# Rezoning Transportation Analysis

Petition Number: 2022-210

**From: Jake Carpenter, PE**  
Jacob.carpenter@charlottenc.gov  
980-221-5675

## Revision Log:

RZ-03

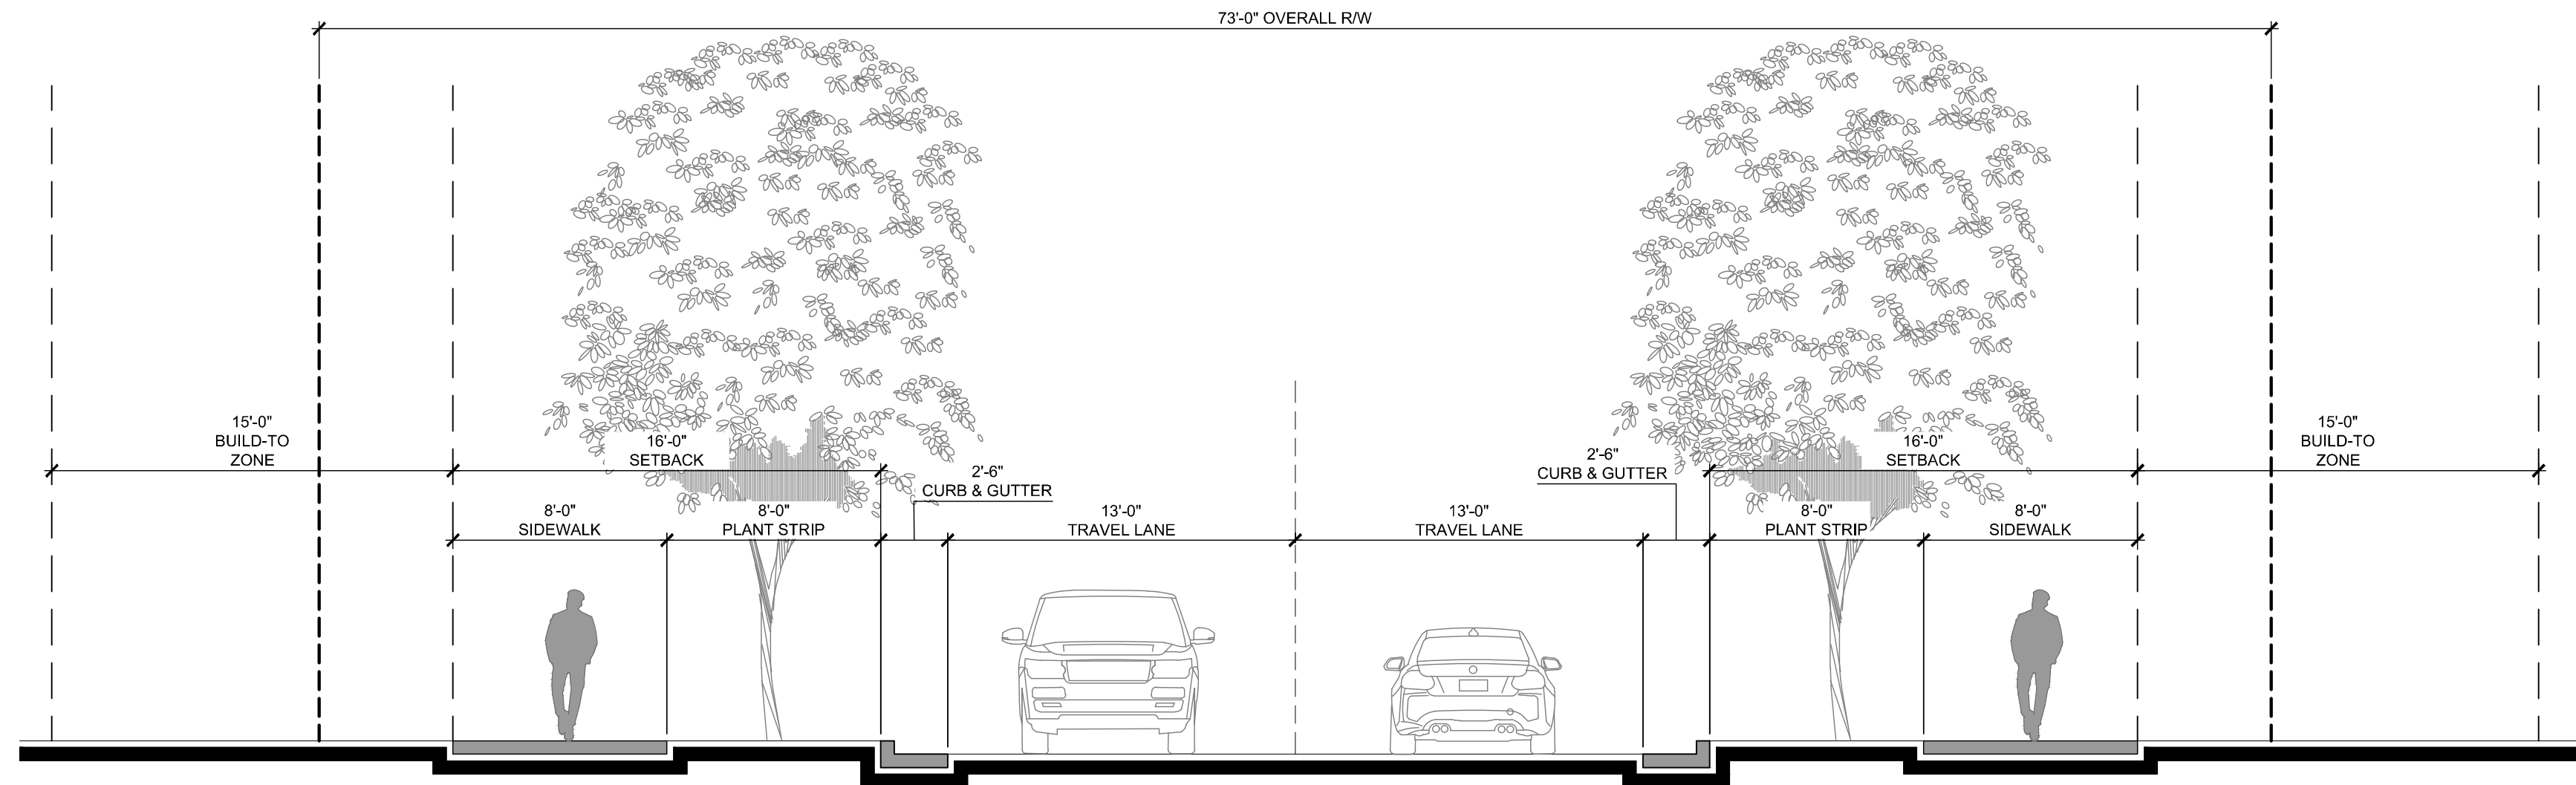
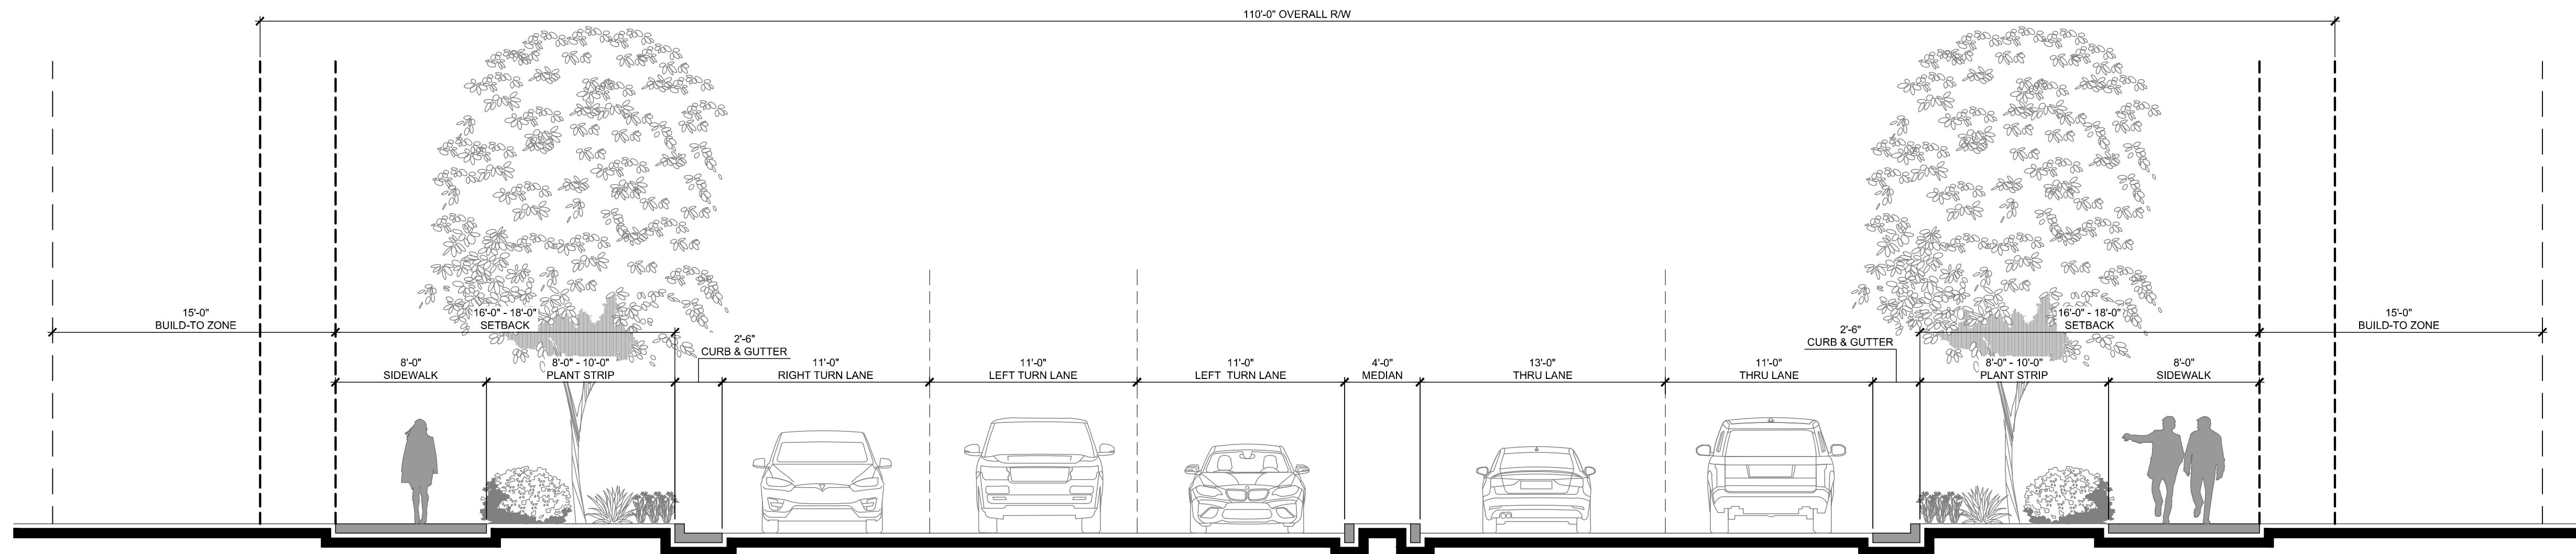
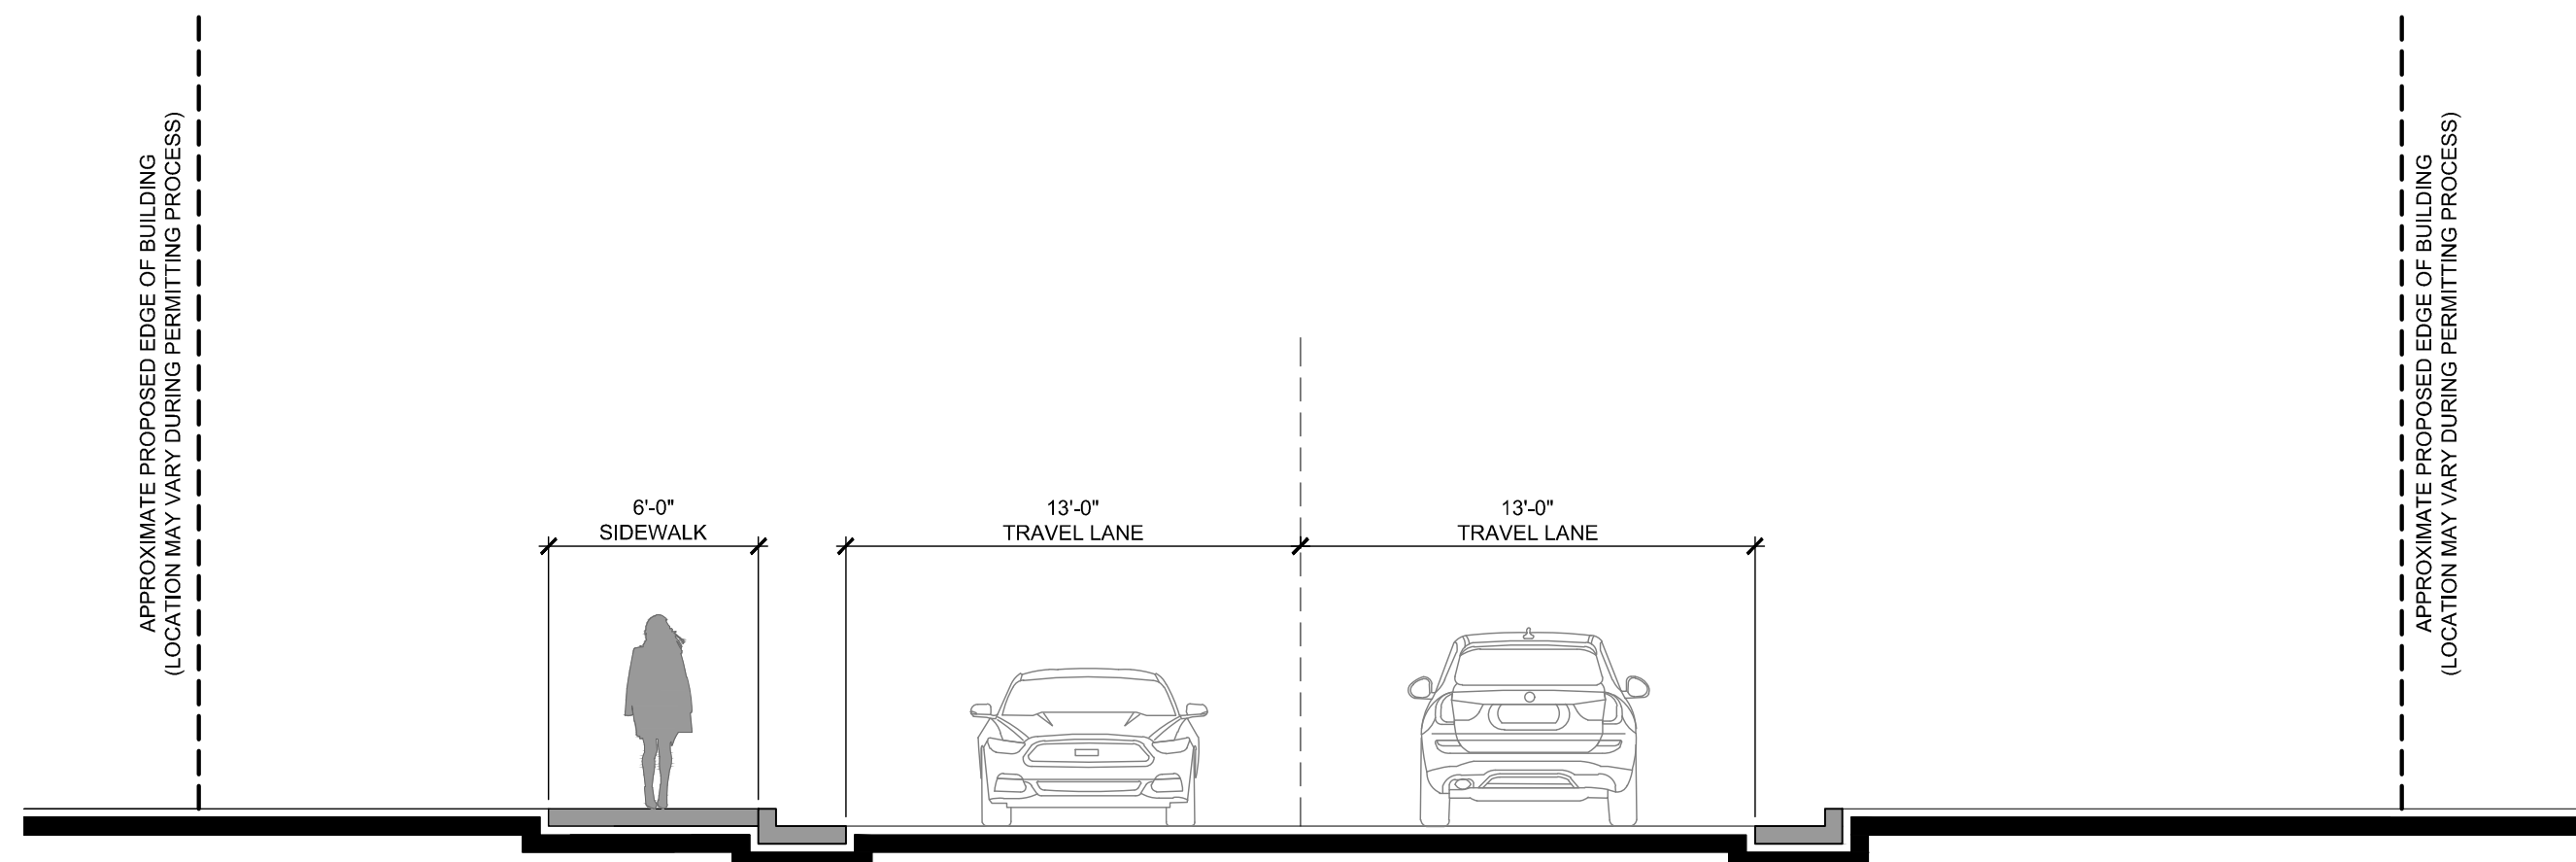
6. **Outstanding Comment 9.20.23:** Revise internal street network to standard public street typical sections per the CLDSM or provide additional information on existing constraints for review and approval of nonstandard typical sections.

Provide additional info on why modifications are necessary
